Our Ref: R/285/17/HH
Your Ref:

Town & Country Planning Act 1990 (as amended)
Town & country Planning (Development Management Procedure) (England) Order 2015
Application for Planning Permission for Works or Extension to a Dwelling

Development Replacement conservatory to east elevation increasing height of garage roof to north elevation, Juliet balcony at first floor level to south elevation, window at first floor level to east elevation for new en-suite.

Location 89 Broadmark Lane Rustington

Site Plan 1/500

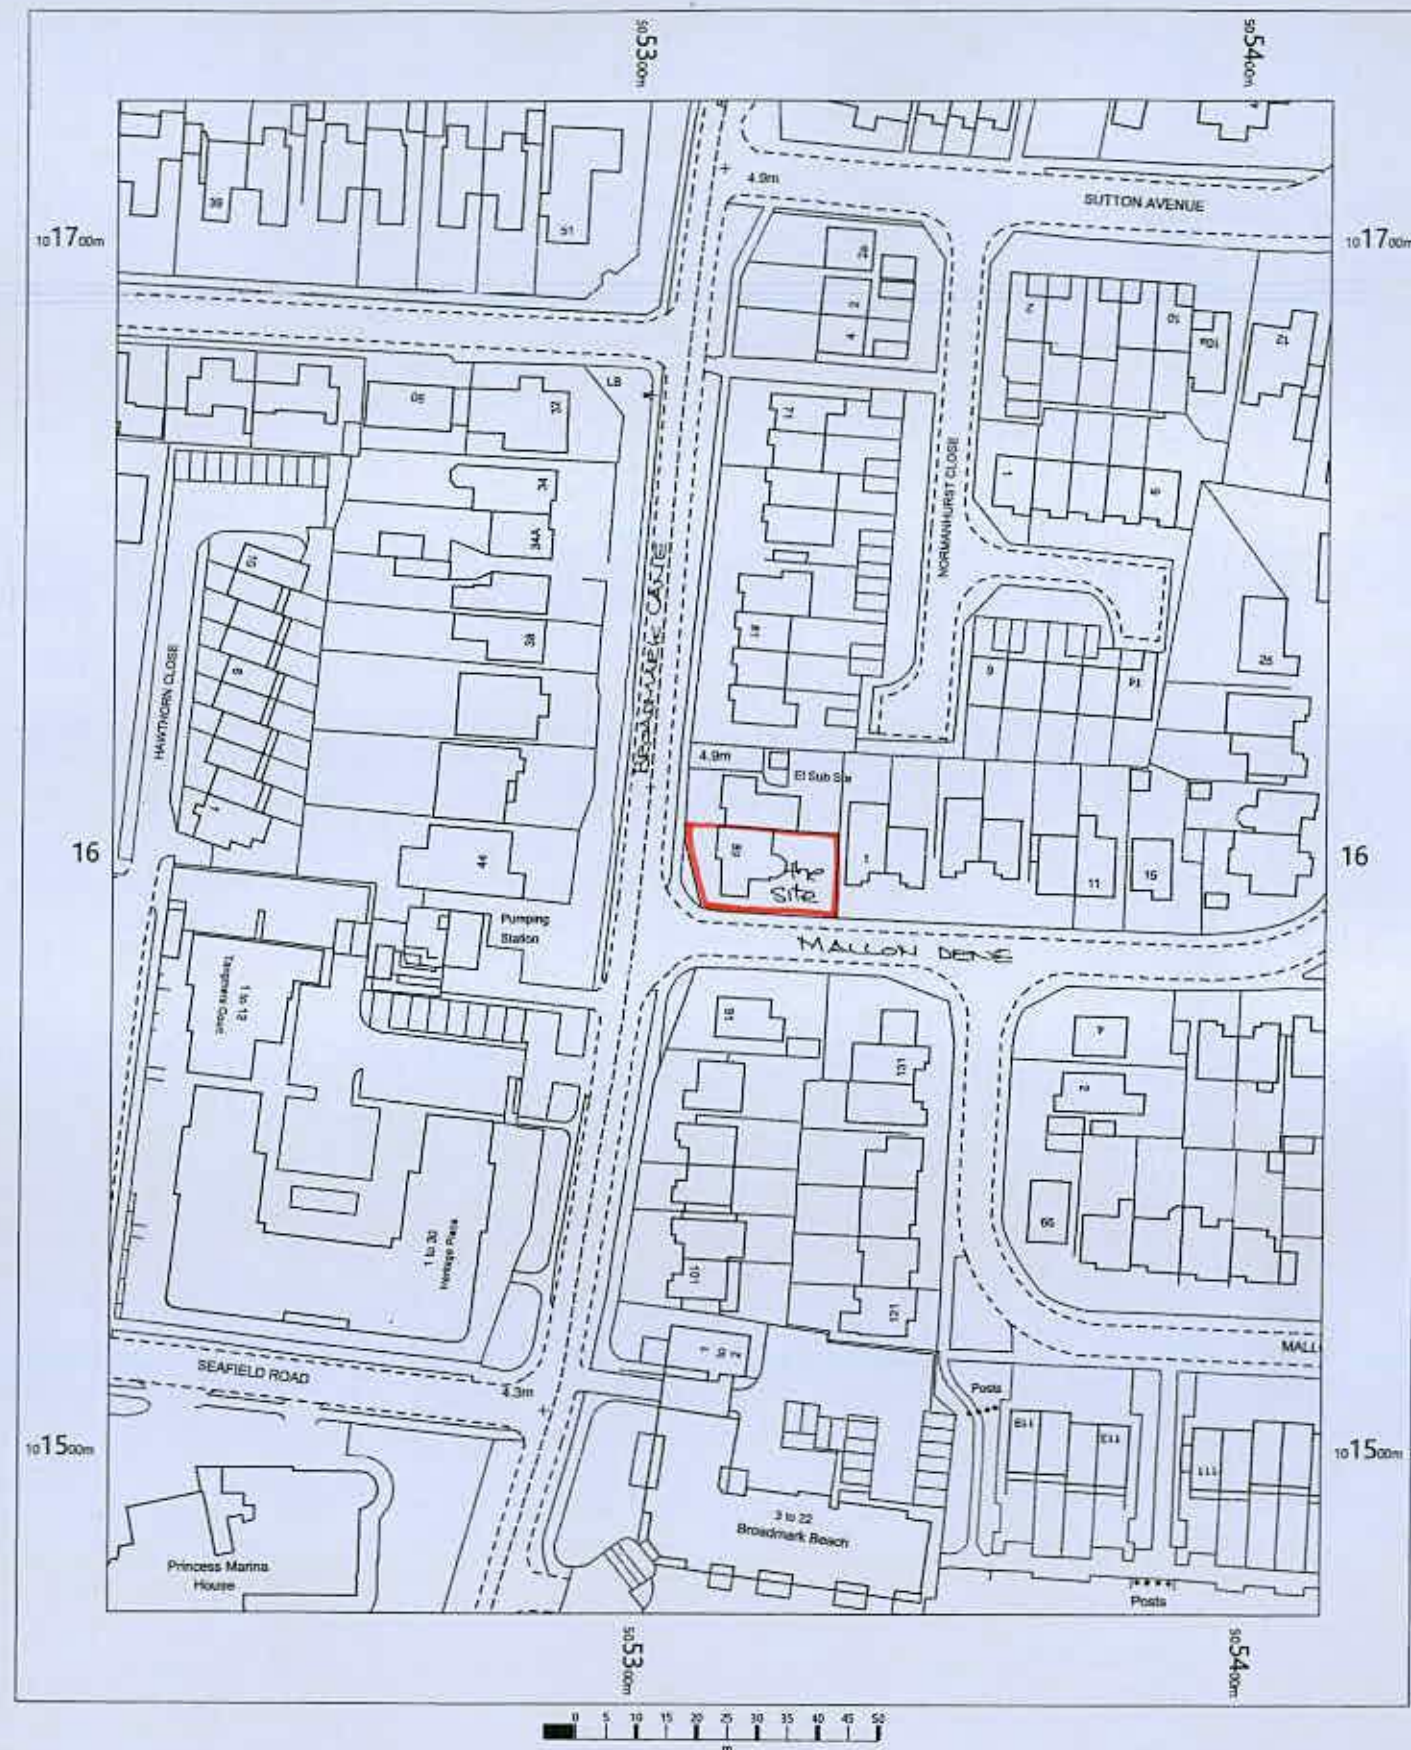
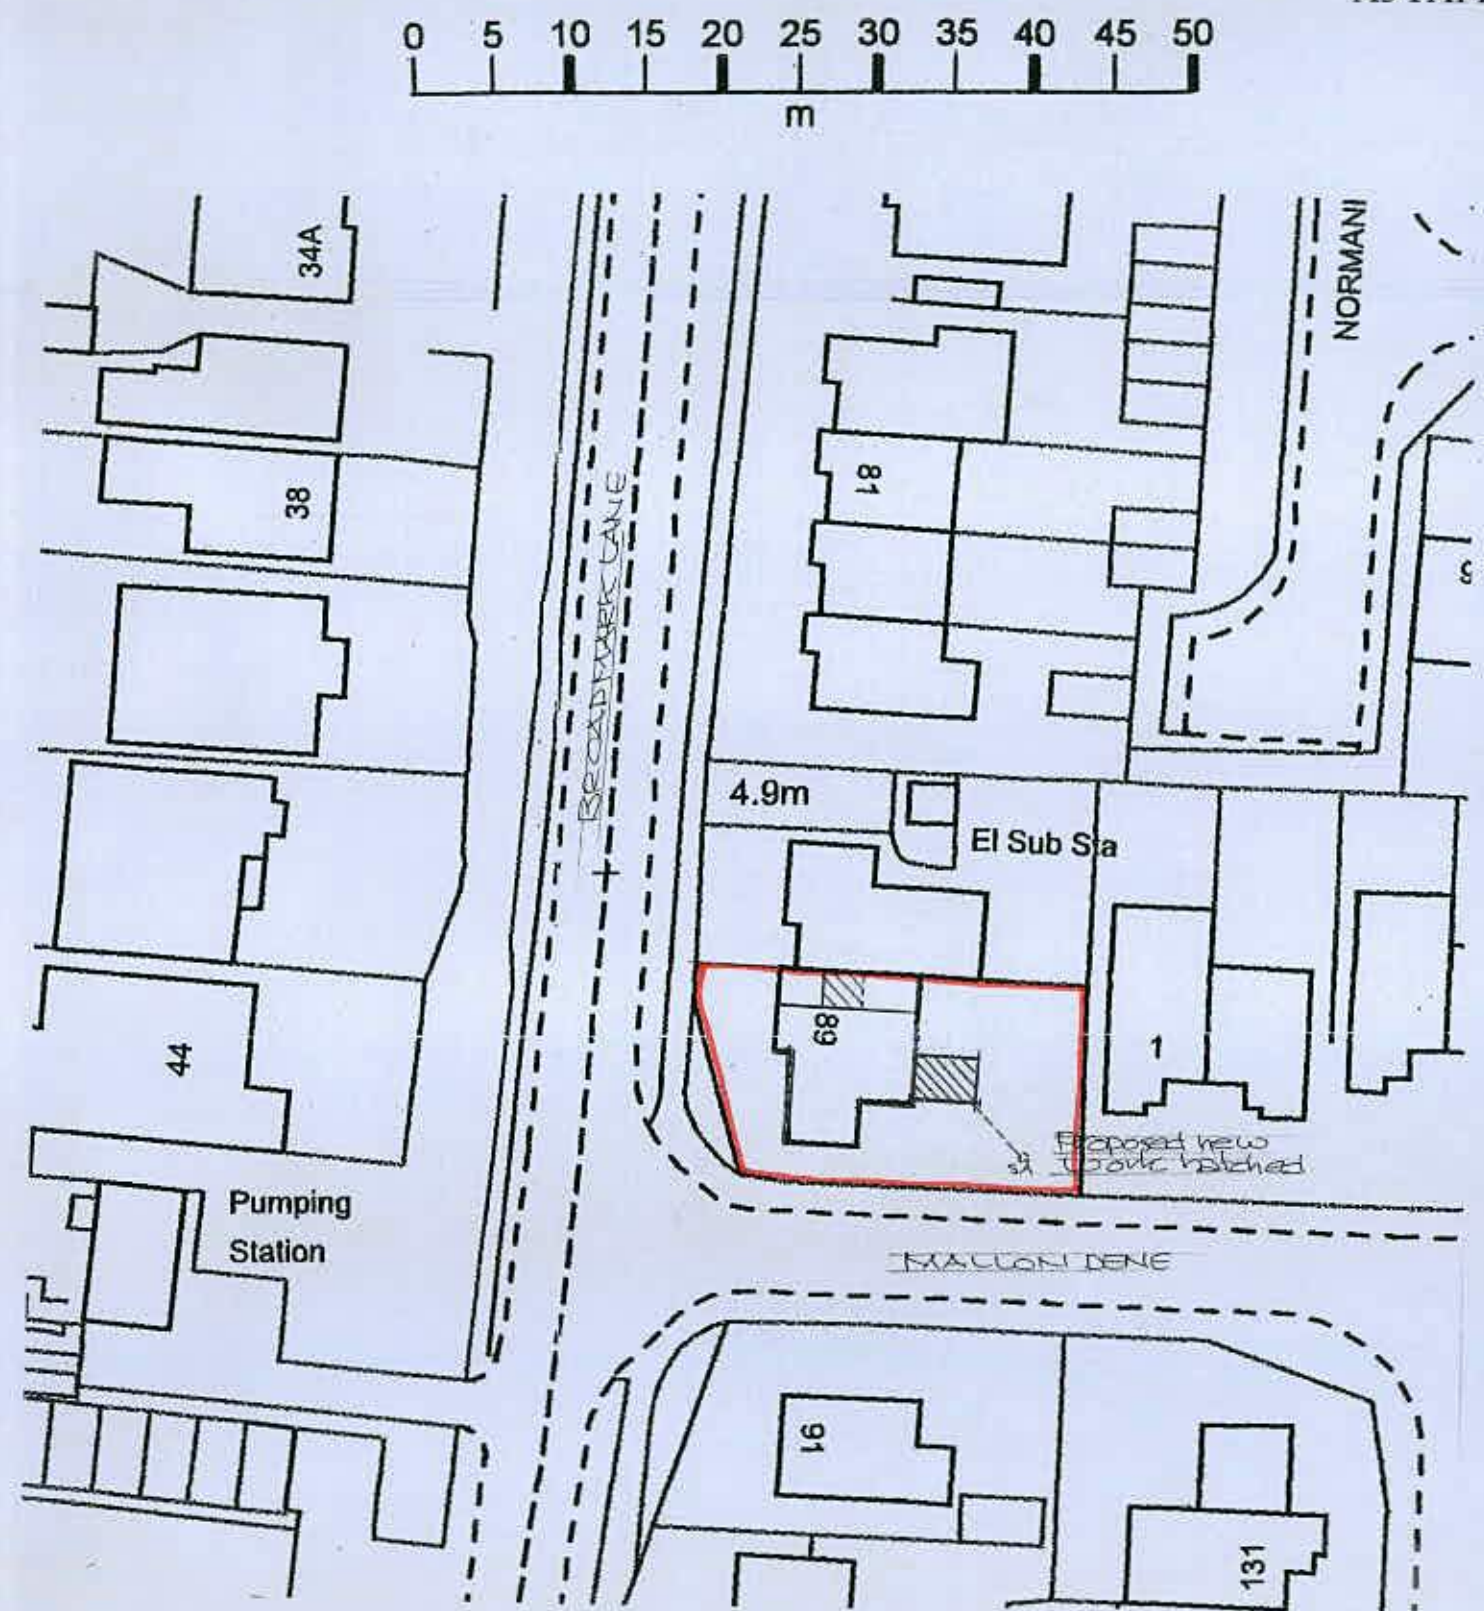
Block Plan - revised

Please submit 1 electronic or 3 paper copies of a revised block/site plan at a scale of 1:500 or 1:200 with the proposed site dimensions clearly indicated from the proposal to the site boundaries. Further details of what must be included on the plan can be found in the National Validation Requirements.
